DOC18/894066  
SSD 9344

**Notice of Exhibition - Redevelopment of Kent Road Public School, 126 Kent Road, Marsfield - SSD 9344**

## Attachment 1 – OEH comments - Redevelopment of Kent Road Public School, 126 Kent Road, Marsfield - SSD 9344

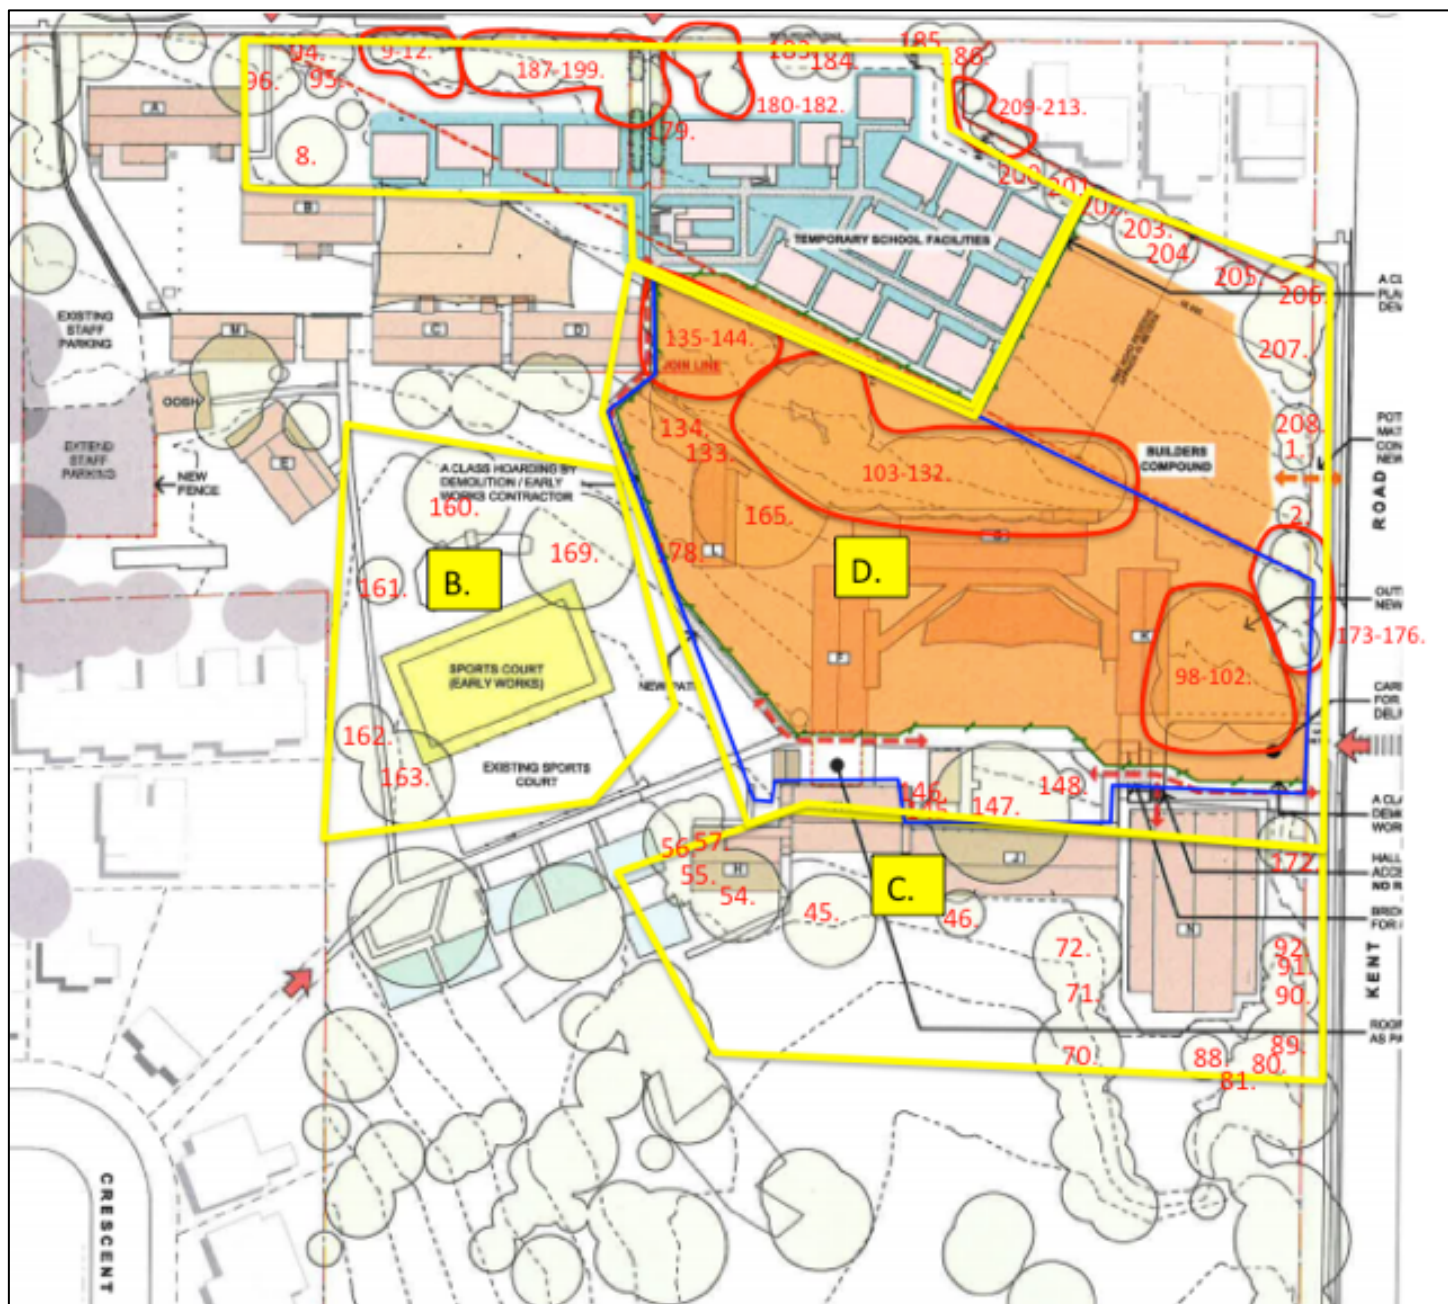
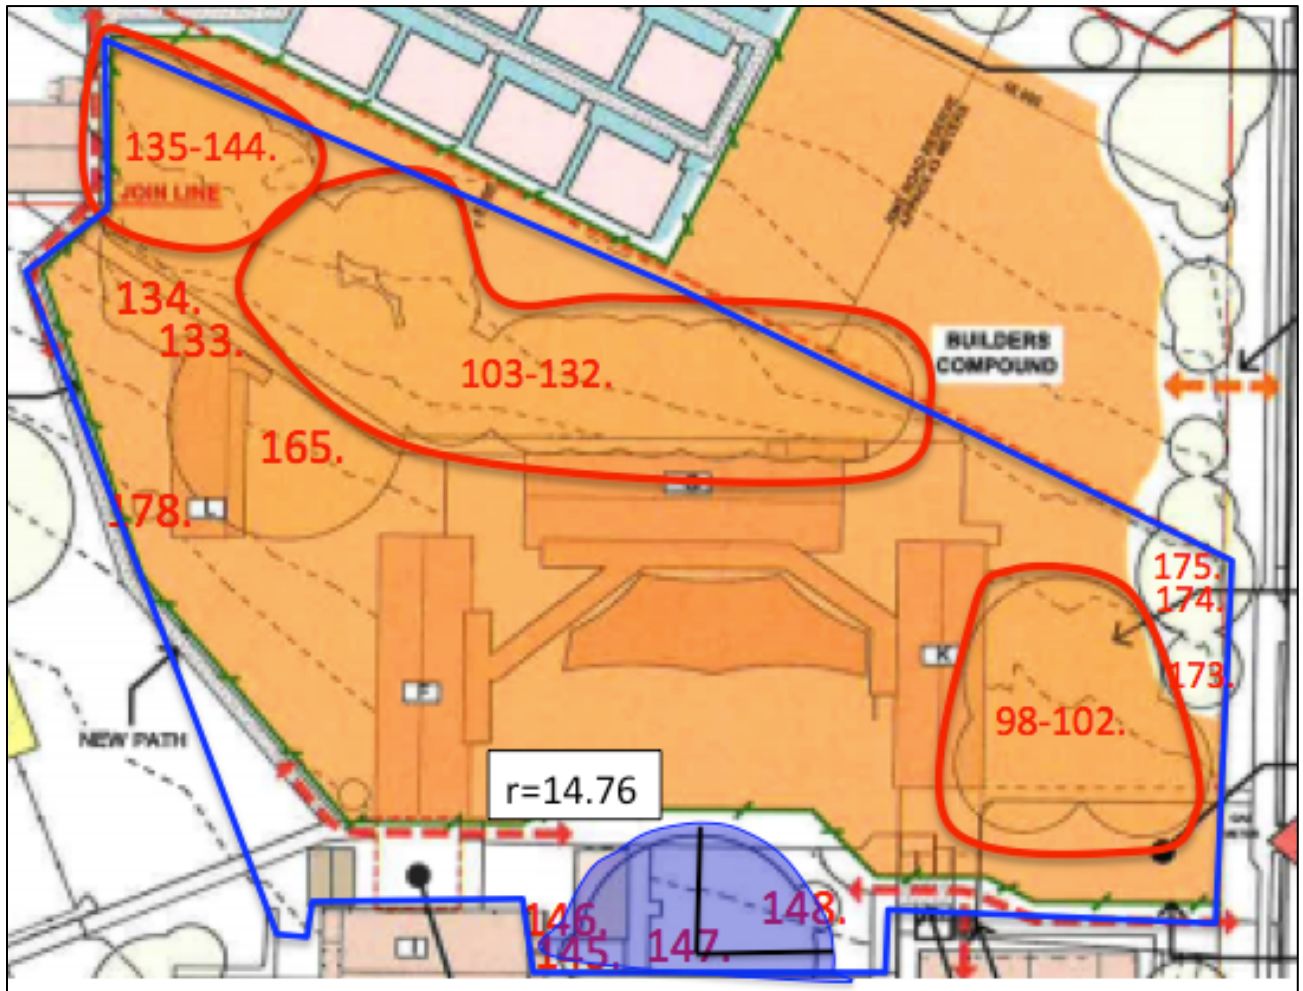
- Trees 134 and 165 are to be aerially inspected by an ecologist prior to their removal. This inspection should investigate the presence of faunal habitats within their canopy and hollowed stems. All fauna within these trees should be safely captured and / or dispersed prior to their removal. Once evacuated all hollows should be covered to ensure they are not reoccupied prior to the trees' removal.

- The northern edge of the new sports court must not be located closer than 5.5 metres from the stem of Tree 169 and no closer than 3.5m from the stem of Tree 163. This will ensure that the encroachment sustained to these trees remains minor (less than 10% of its total TPZ area).
- The group exclusion zone is to be extended in the western direction towards Tree 45. Additional signage should be added stating that 'No construction activity is permitted beyond this point. No construction activity of any kind must take place on the southern side of this fence.
- The high retention value trees within southern portion of the school are identified on the Biodiversity Values Map and are not within the tree impact zones and must therefore be protected and retained.

Figure 3. Landscape Plan within SSD area. Landscape Plan drawn by *iScape Landscape Architecture* (10/2018).

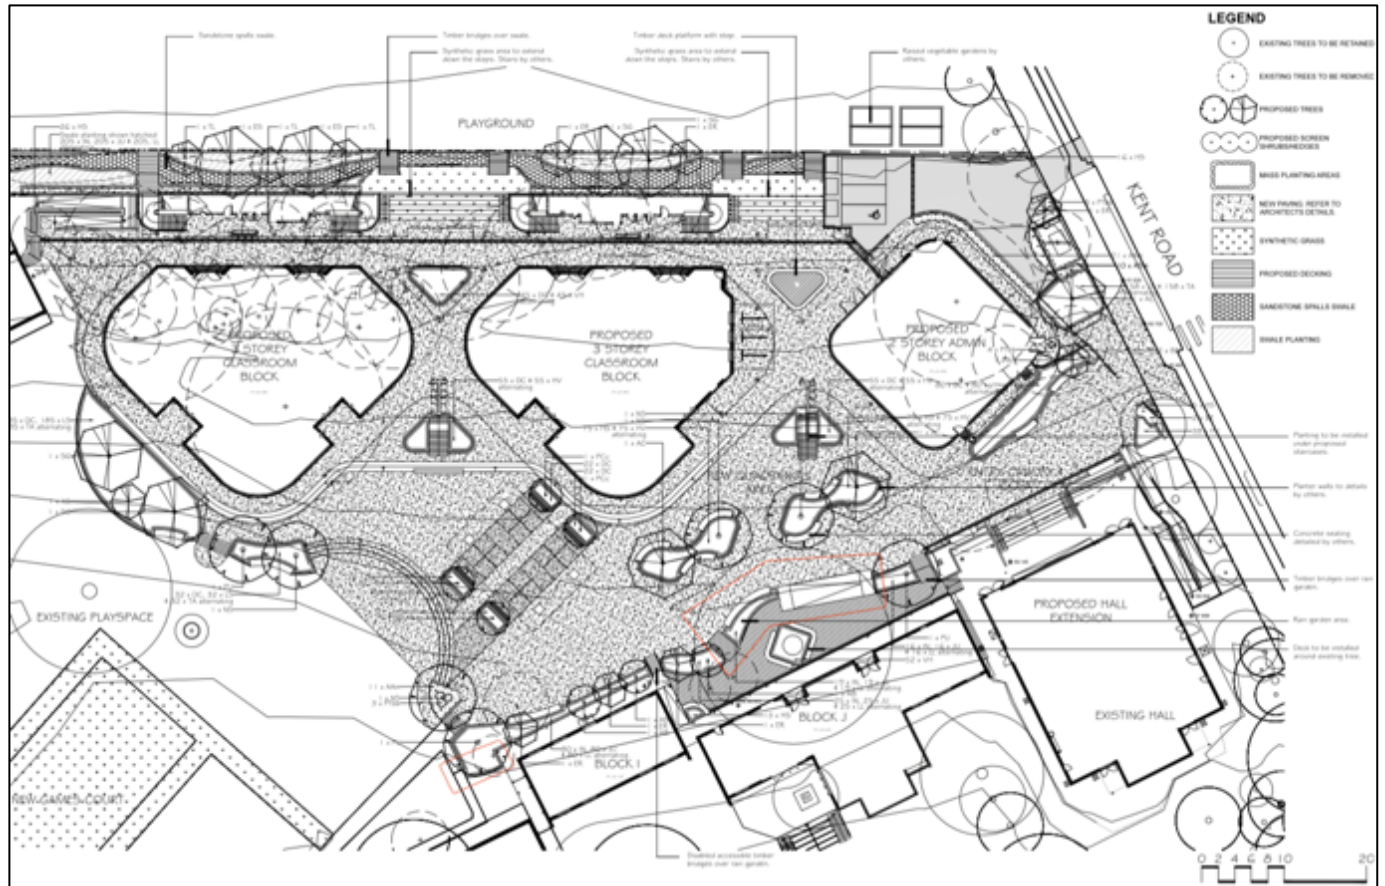
- Landscaping in the Development Site is to use locality derived native species and those found within the PCTs present. The replacement planting must be locally occurring Blue Gum High Forest, Turpentine-Ironbark Forest and Shale – Sandstone Transitional Forest species.

- detail how much green cover is provided on site
- what canopy cover percentage is achieved on site and how it is consistent with this target.
- ensure that trees removed as a consequence of the proposal must be replaced, in accordance with Section 6 of the Urban Forest Technical Manual (Tree Management Technical Manual, City of Ryde 2012) to effectively maintain the Urban Forest canopy.
